SUPPLEMENTAL/AMENDED INFORMATION
TO DRAINAGE REPORT
DATED APRIL 23, 2013

INLAND KENWORTH
Fortuna Rd West of 76th Street NW

RESPONSES OF CITY OF ALBUQUERQUE COMMENTS:

**Re: Inland Kenworth, Fortuna Road, Drainage Report and Conceptual Grading
and Drainage Plan**

CG-103
of Sheets

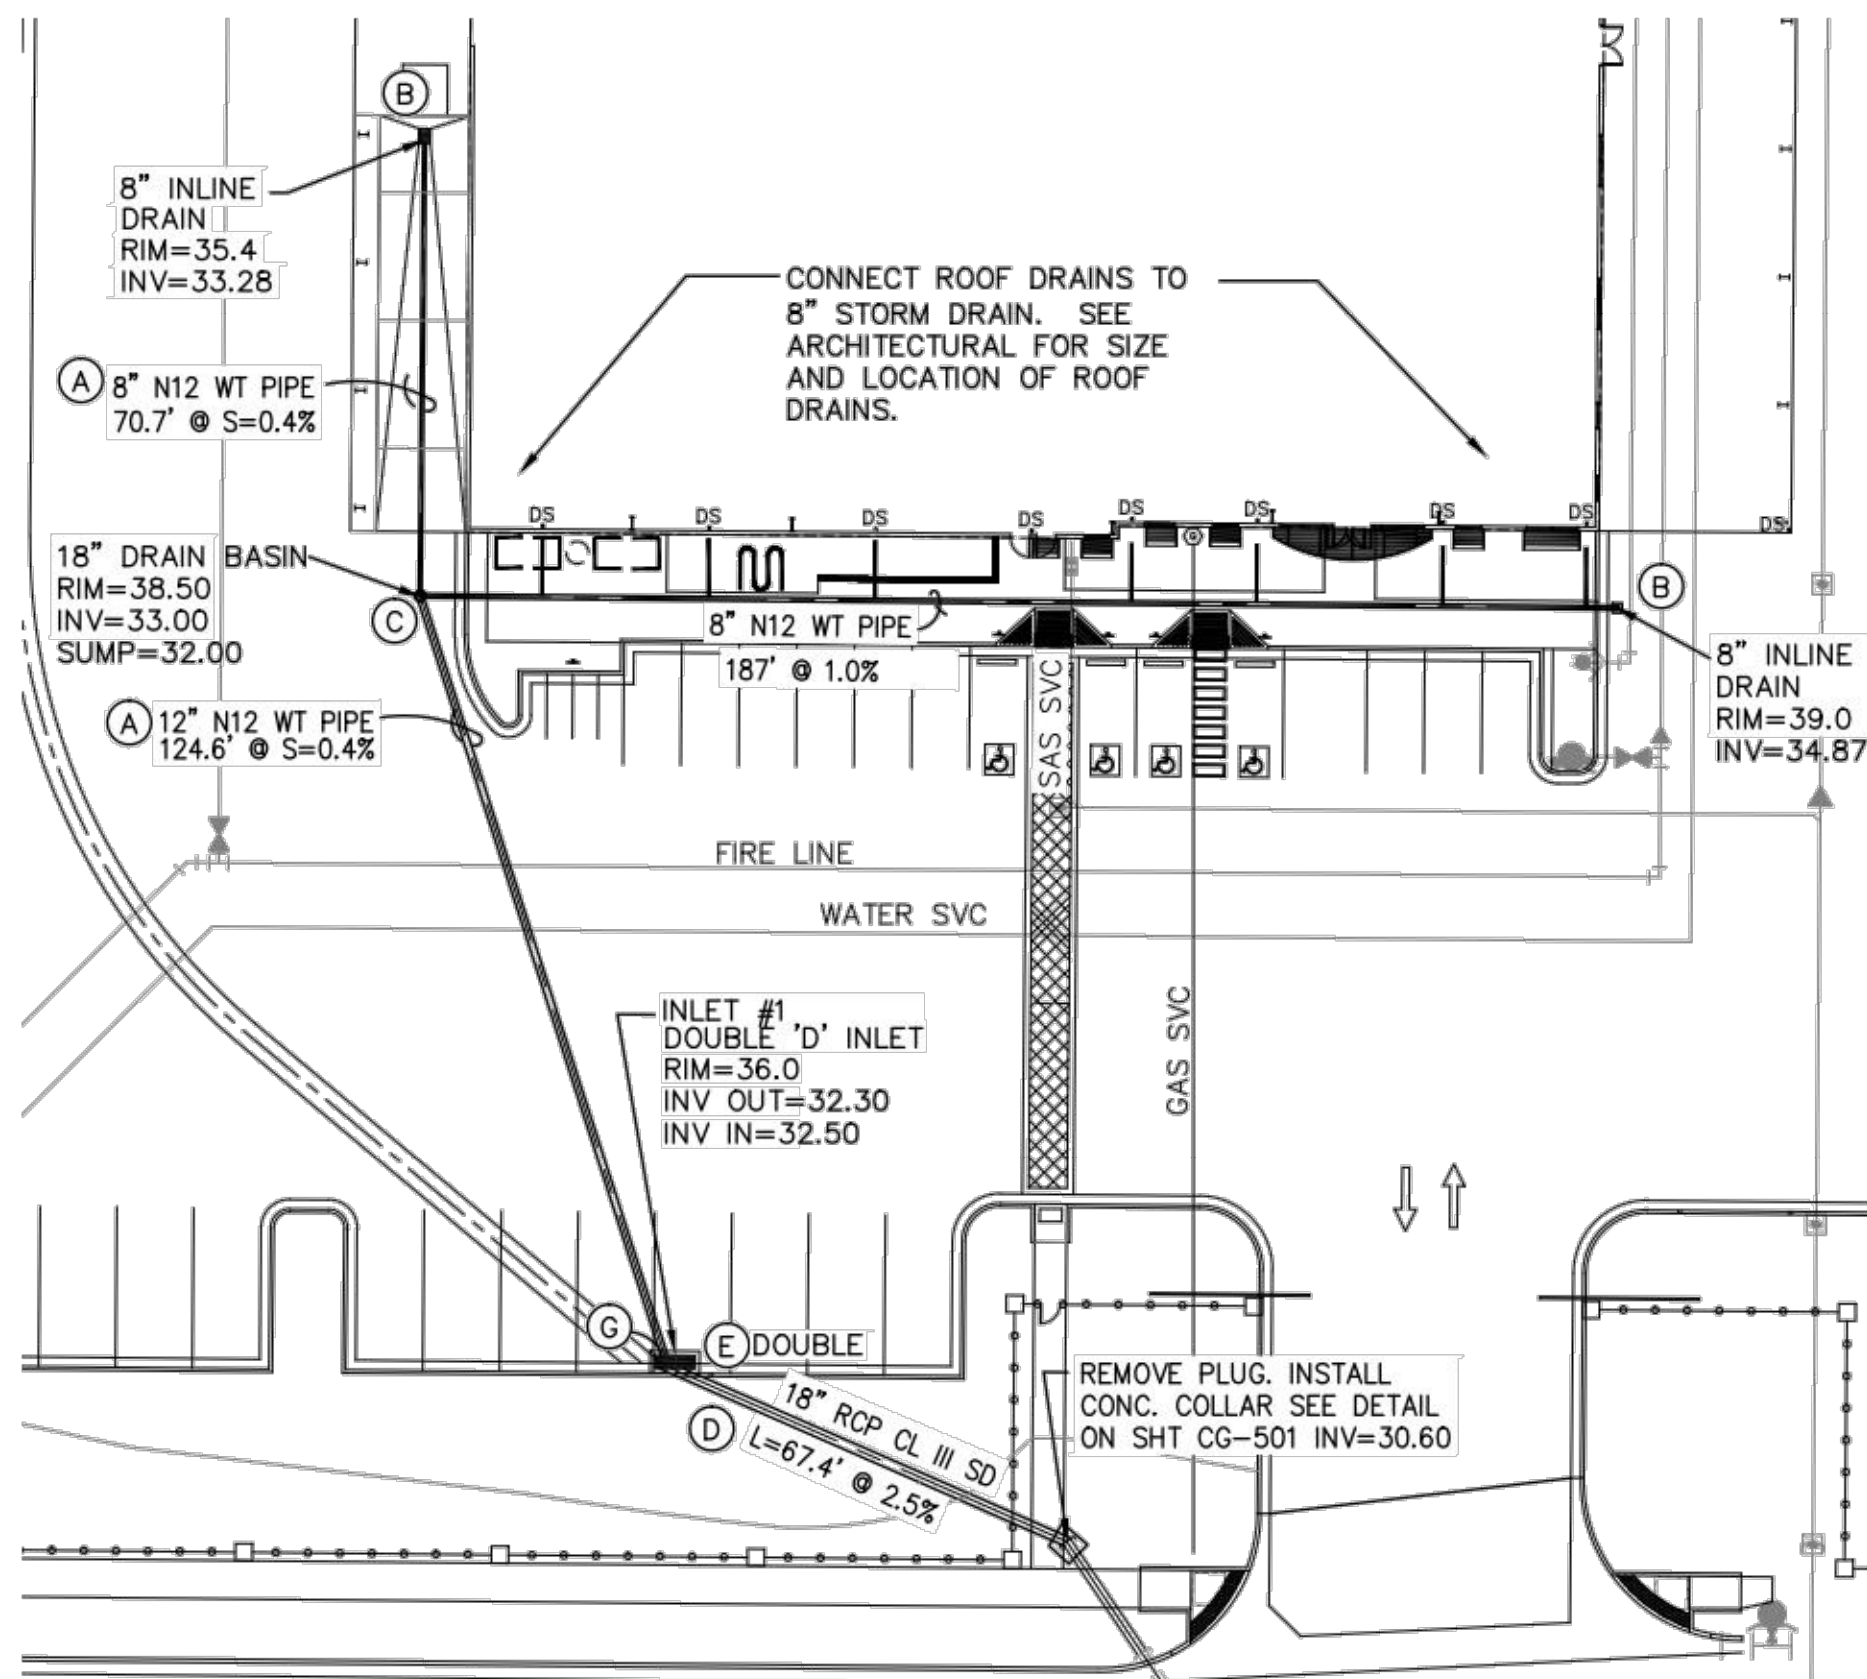
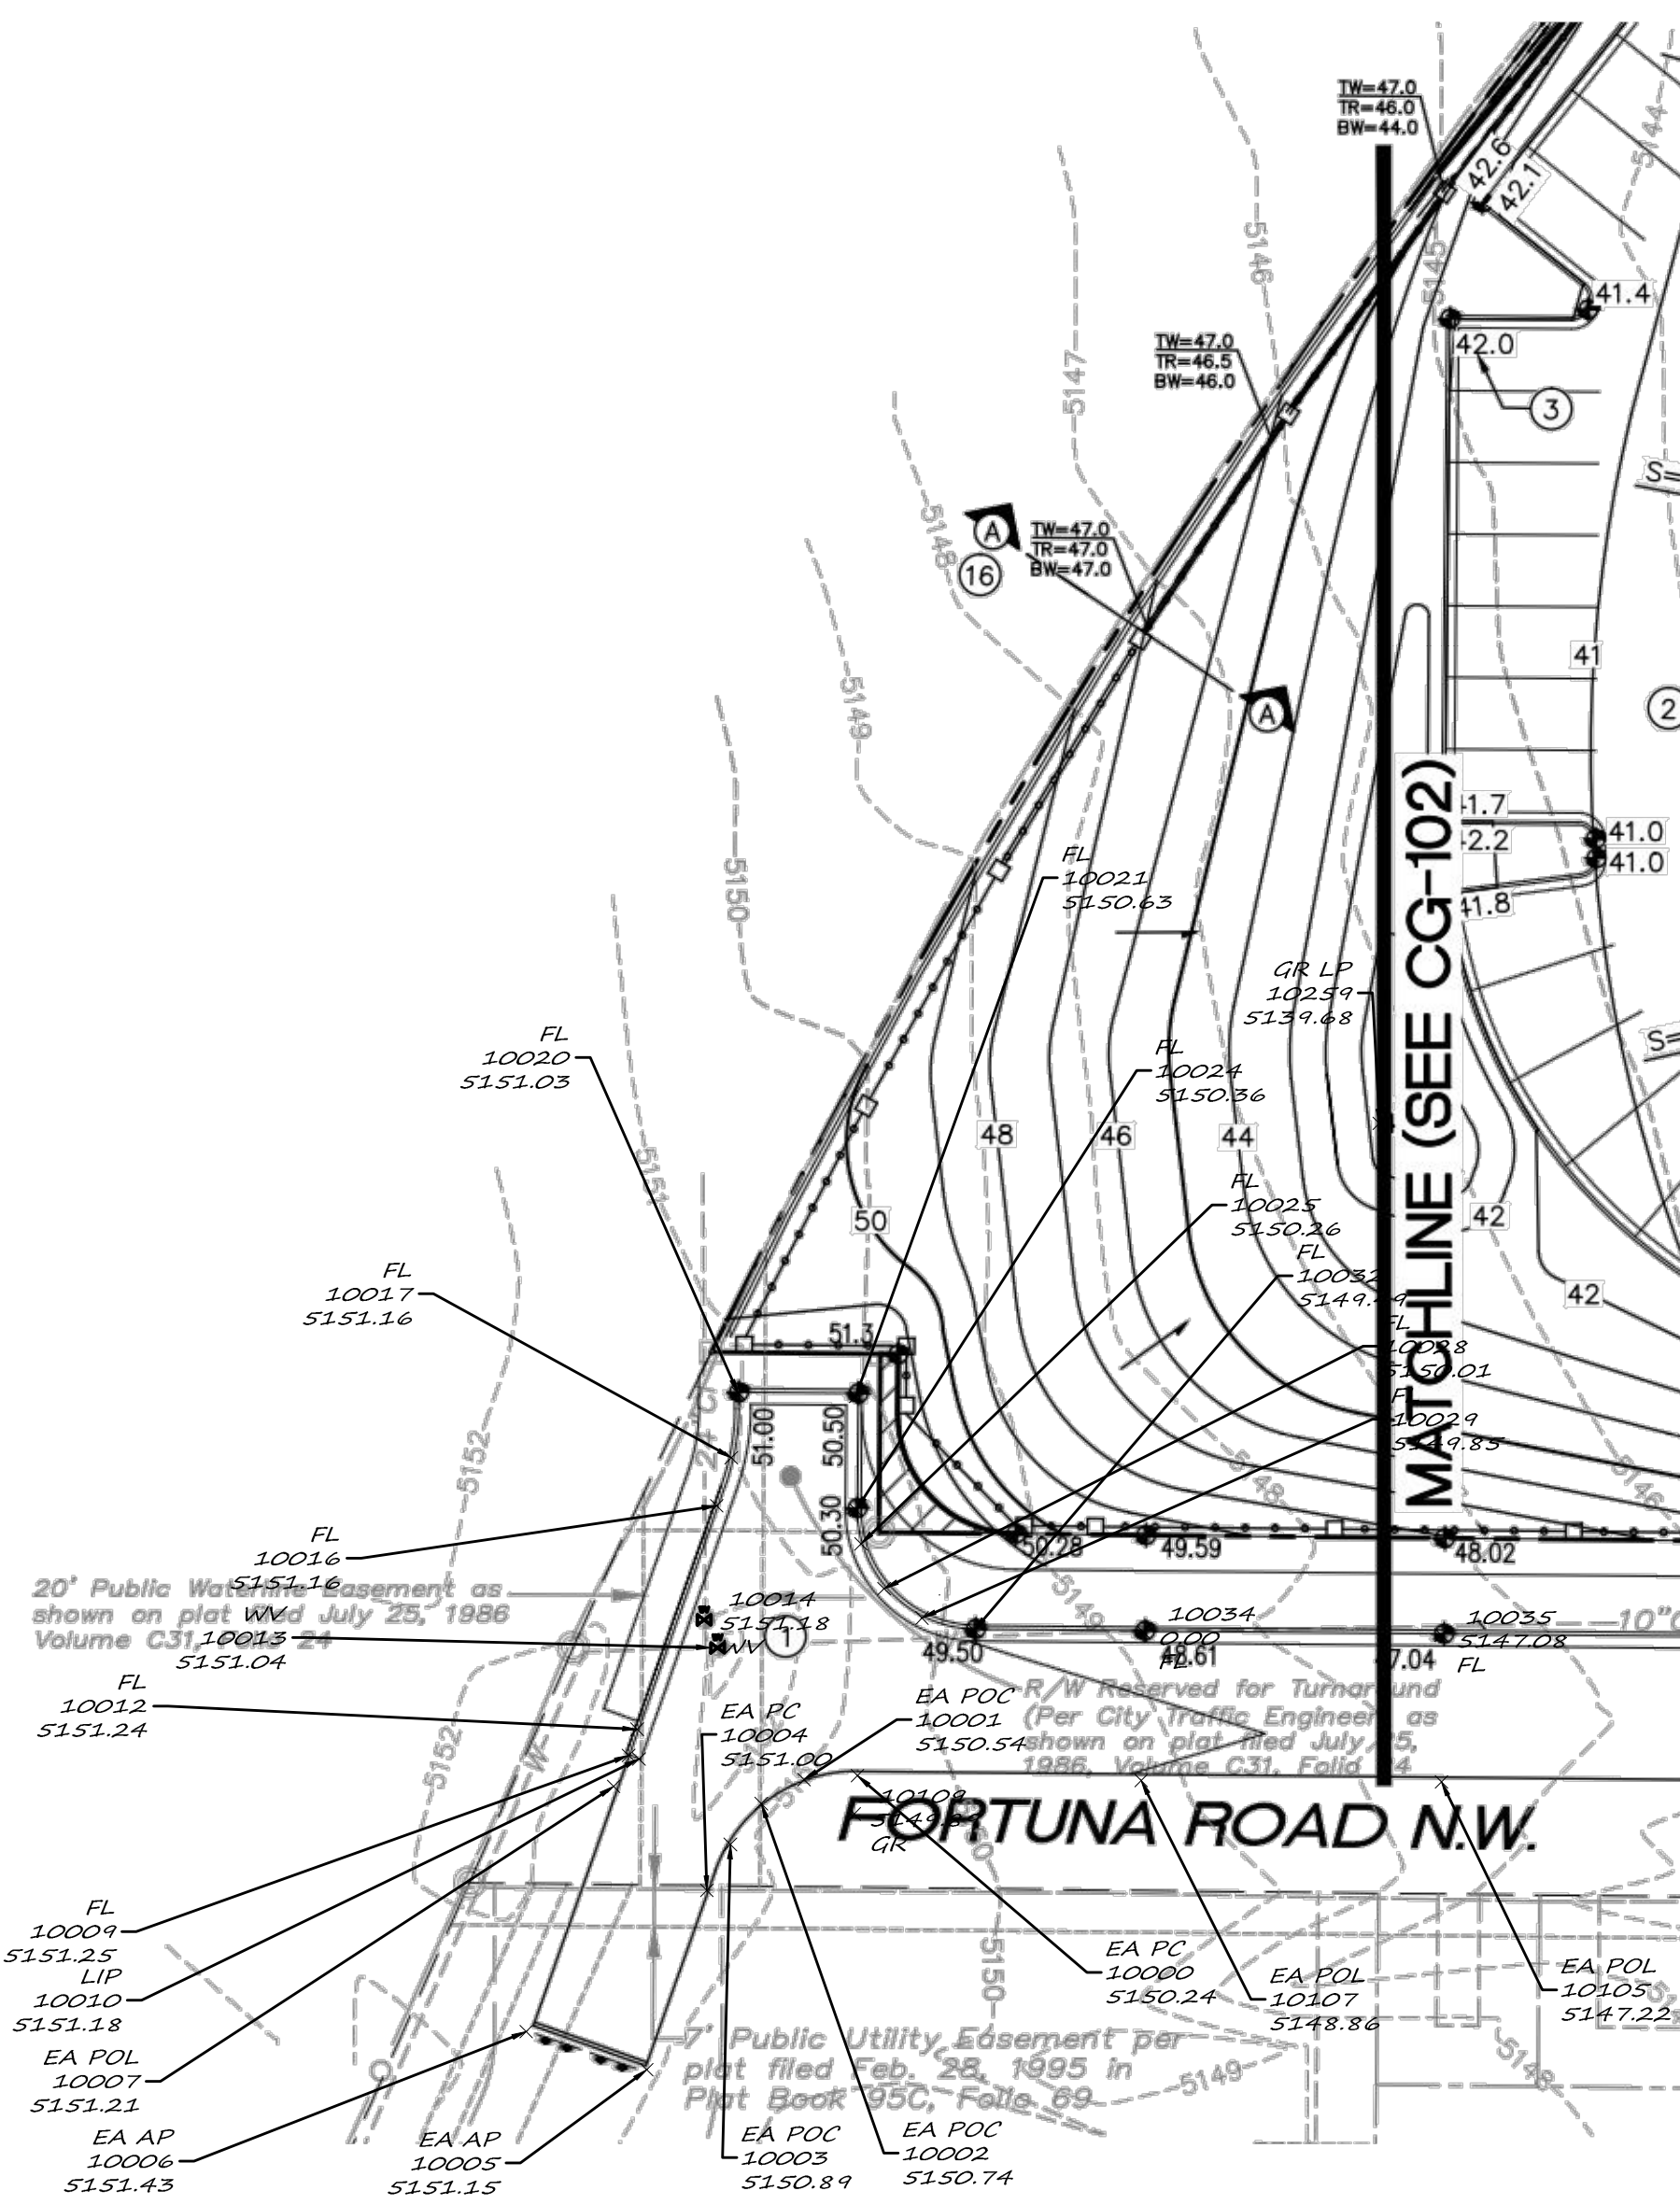
1. Per the DPM, p. 22-106, where the peak flow in the proposed lateral exceeds 10 percent of the main line, the angle of confluence should not exceed 30 degrees. This can be worked out at DRC.

- 1) Two sheets are numbered CG-101.
- 2) Please include proposed flow lines and back of sidewalk elevations along Fortuna Rd.
- 3) Provide inlet capacity calculations. Assume 50% clogging factor in your calculations.
- 4) Add all the curb opening sizes on the plans.
- 5) Provide calculations for the channel located east side of Basin 2. Include a section for the channel on the plan. Can the runoff overflow the channel when making a 90 degree turn?
- 6) Add all the storm drain pipe sizes to the plan.
- 7) The runoff appears to be block at the north east corner of the property where the offsite runoff enters the site.
- 8) Based on the documents provided the allowable discharge is 3.76 cfs/ac. Therefore, the total discharge is (8.86 ac x 3.76 cfs/ac) 33.31 cfs, and the plan shows an allowable discharge of 34.60 cfs. Please clarify.

1. The storm drain has been revised to provide a max. 30 degree angle of confluence—see attached grading plan and storm drain calculations.
2. Capacity calculations for inlets are included.
3. Channel has been eliminated and replaced with 2- Type C inlets and storm drain.
4. Channel has been eliminated.

- 6) Storm drain sizes have been added to the plan—see sheet CG-103 for details.
- 7) There is a small stilling basin at the outlet of the culverts at the northwest corner of the site. Inverts of the culverts are 33.4 and 33.6, and storm water will overflow to the drainage swale in the NMDOT easement at an elevation of 34.
- 8) Drainage calculations on grading plan were incorrect. Calculations included in approved drainage report dated April 23, 2013 are correct showing 32.2 cfs discharging from site which is less than the 33.3 cfs allowable.
